From: Carol Reynolds
Sent: 21 December 2018 14:55
To: Anita Gardner
Subject: FW: FG/171/18/DOC - Yeomans Honda Discharge of Conditions - External Lighting

From: Kevin Conlon [REDACTED]
Sent: 20 December 2018 14:05
To: Anita Gardner
Cc: Bob Bevan; Steve Duffy; Ali Riza Yozdhanla; Graham Taylor
Subject: FG/171/18/DOC - Yeomans Honda Discharge of Conditions - External Lighting

Please find attached amended scheme for Honda Worthing 11-07-18 REV 1

Honda Worthing 11-07-18 EXT REV 0

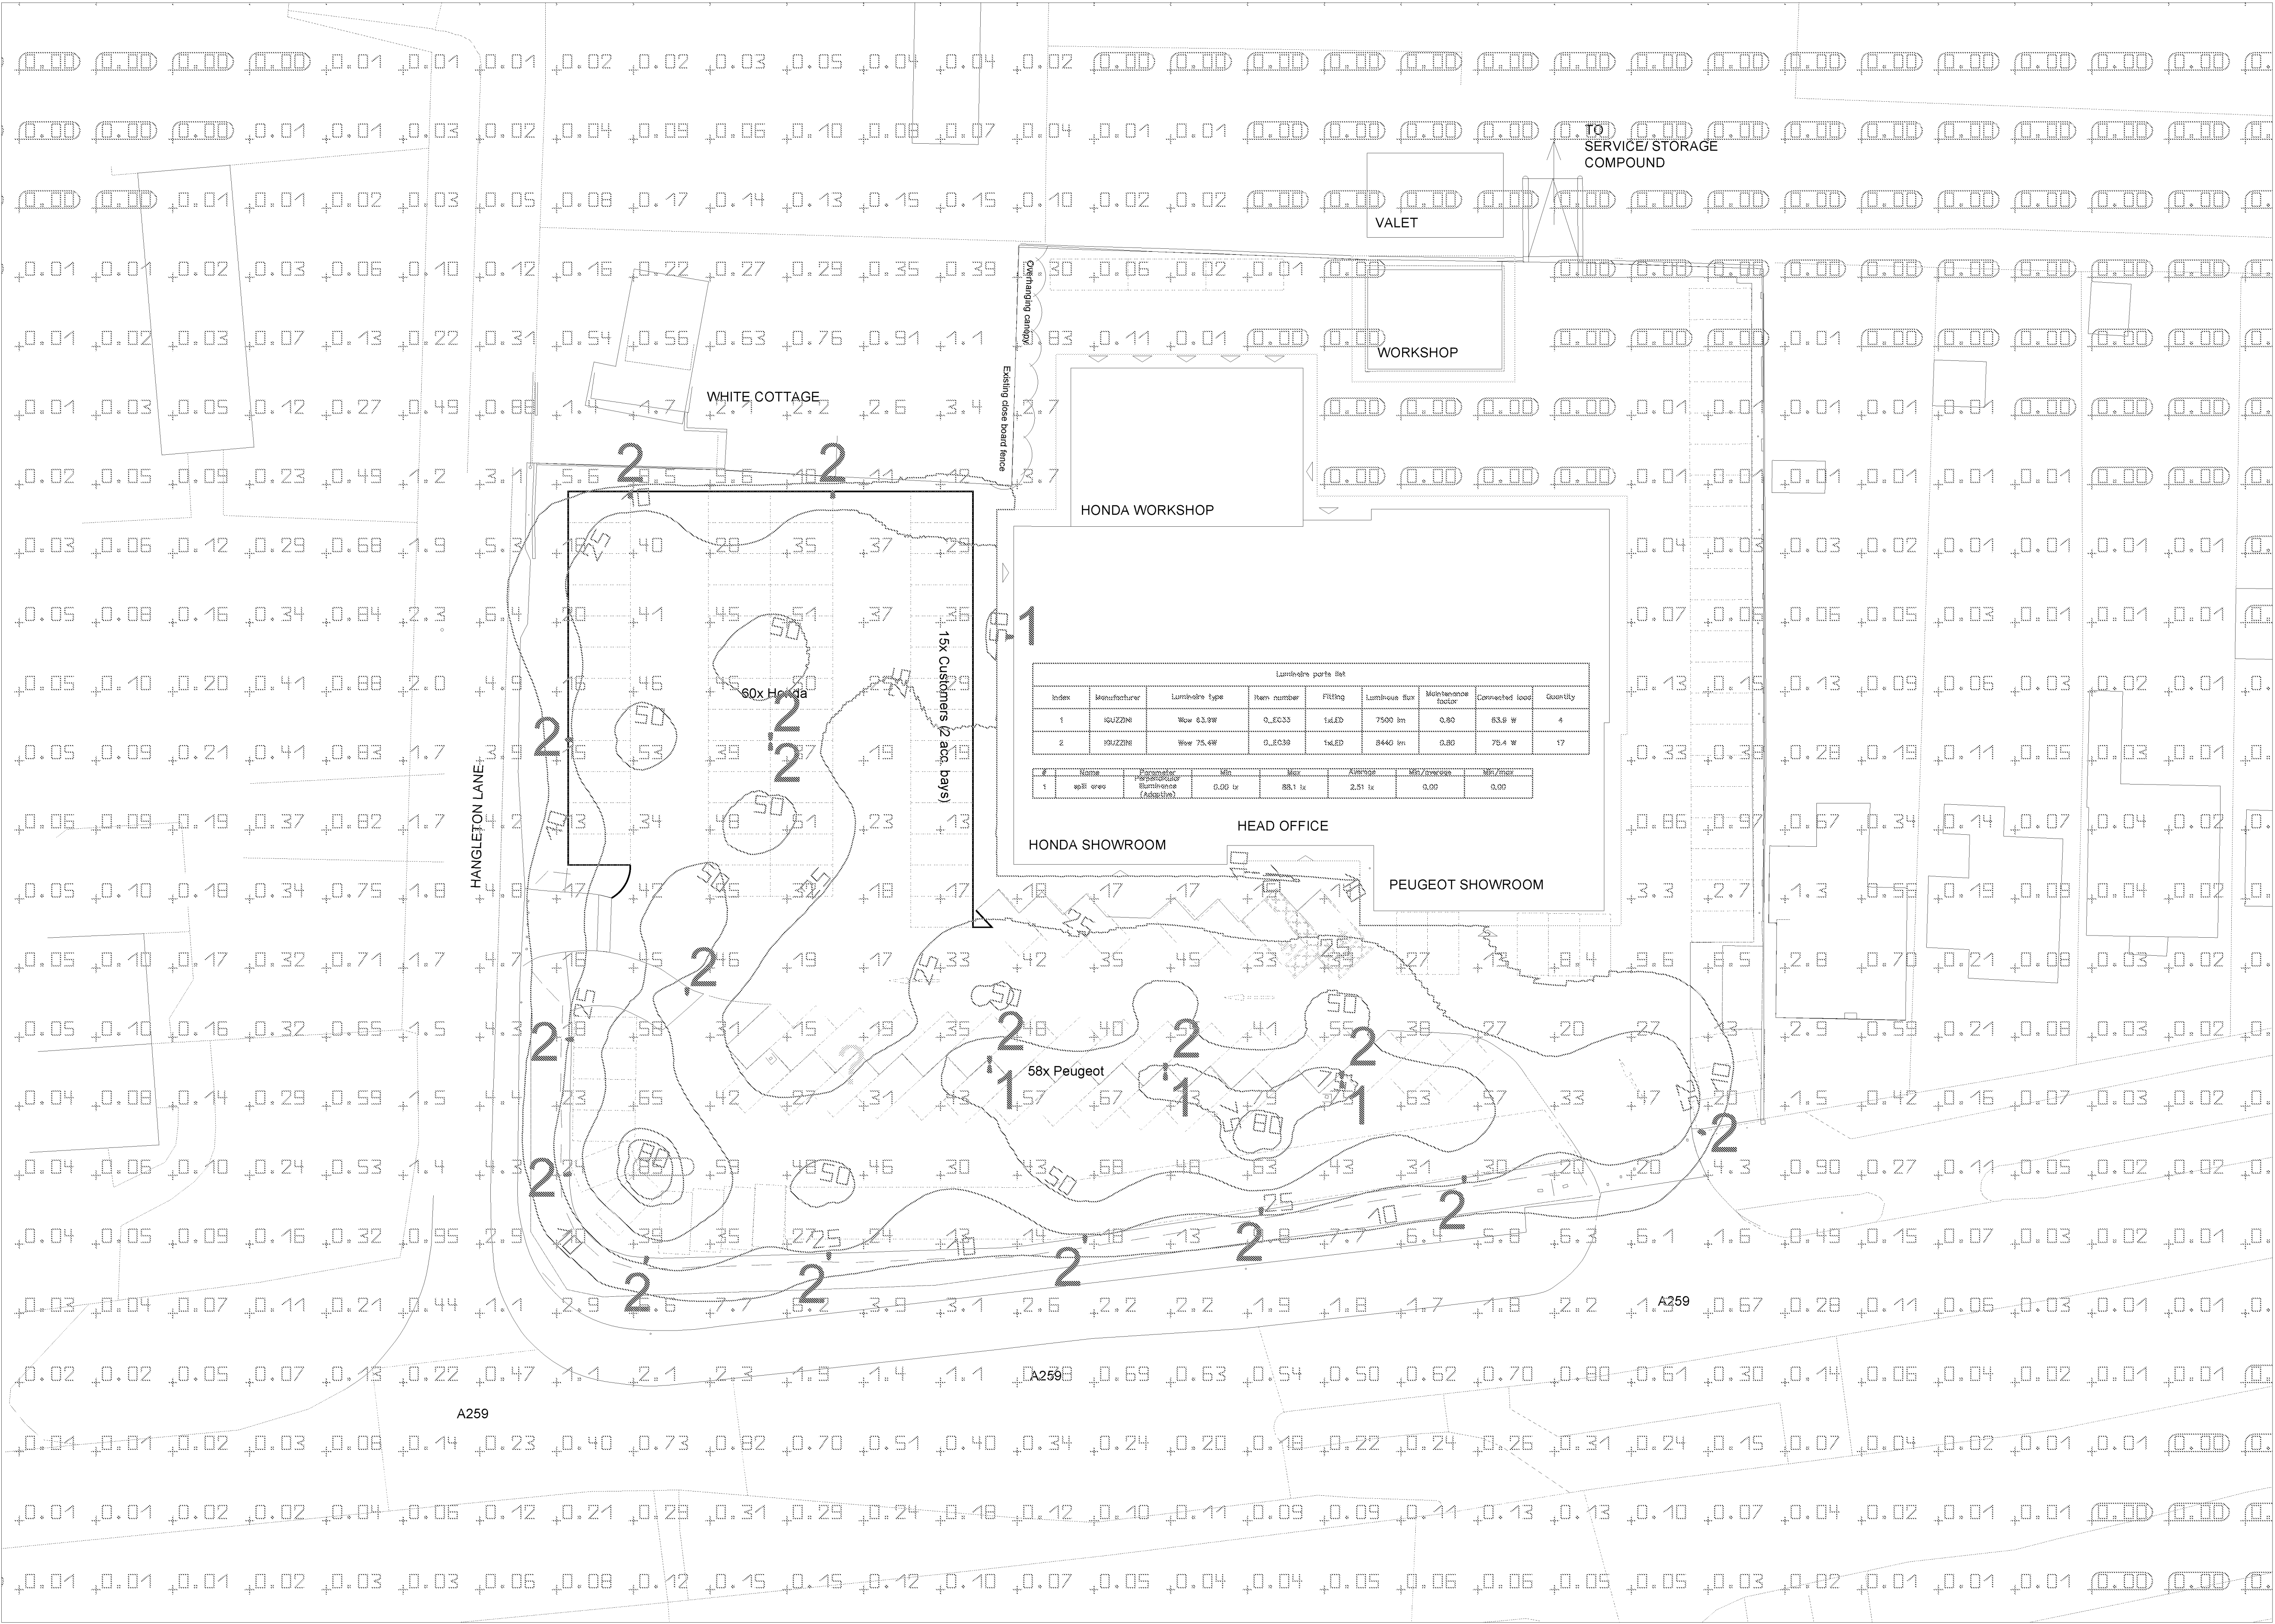
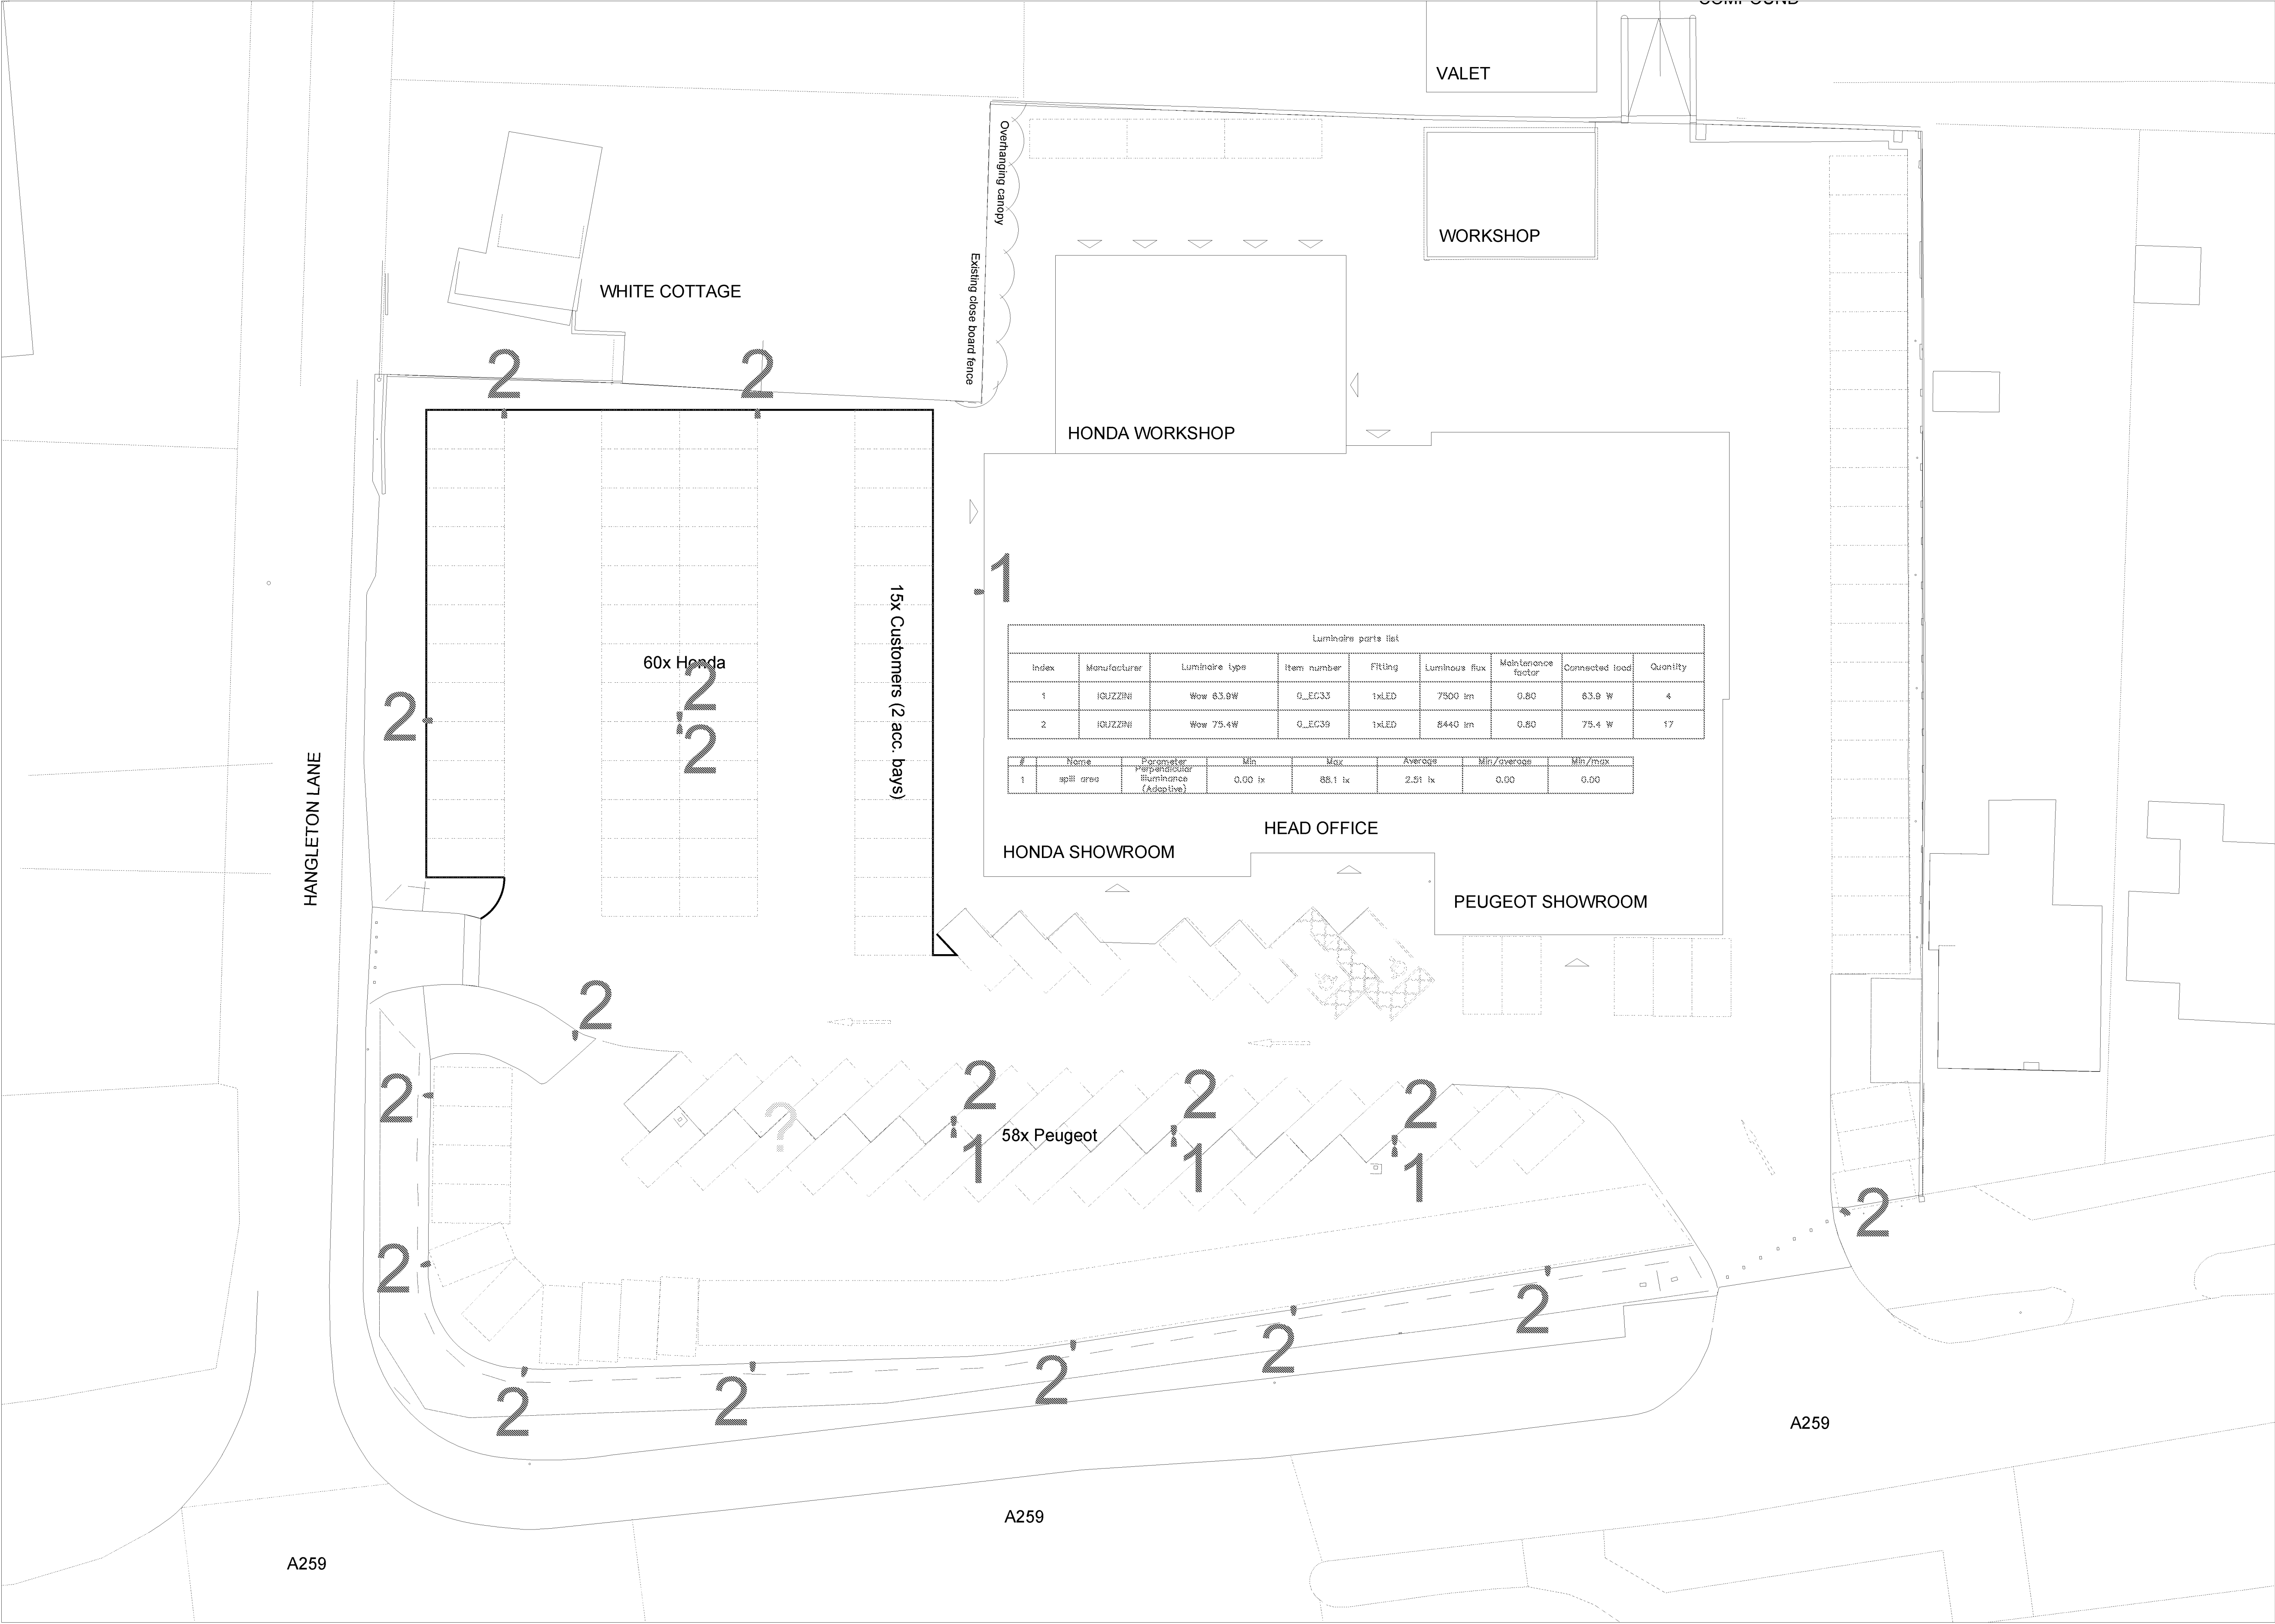
Environmental Health: The above detail provides immediate protection for the neighbouring premises 'White Cottage,' which had not been given due consideration in the original Lighting Plan. I await discussion with the applicant's experts as to measures which will be taken to prevent lighting further away on the site from having adverse impact on this property.

1. Angled ref. 2 fittings on 'white cottage' boundary a further 5° to 10° to reduce back-spill and potential view of light source
2. Moved new wall-mounted fitting further 'down' (looking at plan) from 'white cottage' boundary to reduce spill and move product further away from being seen
3. Angled ref. 2 fitting on new double-head column which faces toward 'white cottage' boundary -5° to reduce spill and potential view of light source
4. Instead of altering fitting selection or column heights, I'm suggesting fittings marked '*' could be dimmed to 50% [post-curfew?] using astro timer etc. with additional switched live provided to product as per installation instructions

New lighting plot attached shows this situation with '*' fittings dimmed to 50%. I have shown additional detail including 1 lx boundary which does fall beyond site extent however appears to stop short of actual neighbouring property. After this boundary, spill is more-or-less negligible, especially considering calculation does not include soft/hard landscaping present which would attenuate lighting beyond site even further.
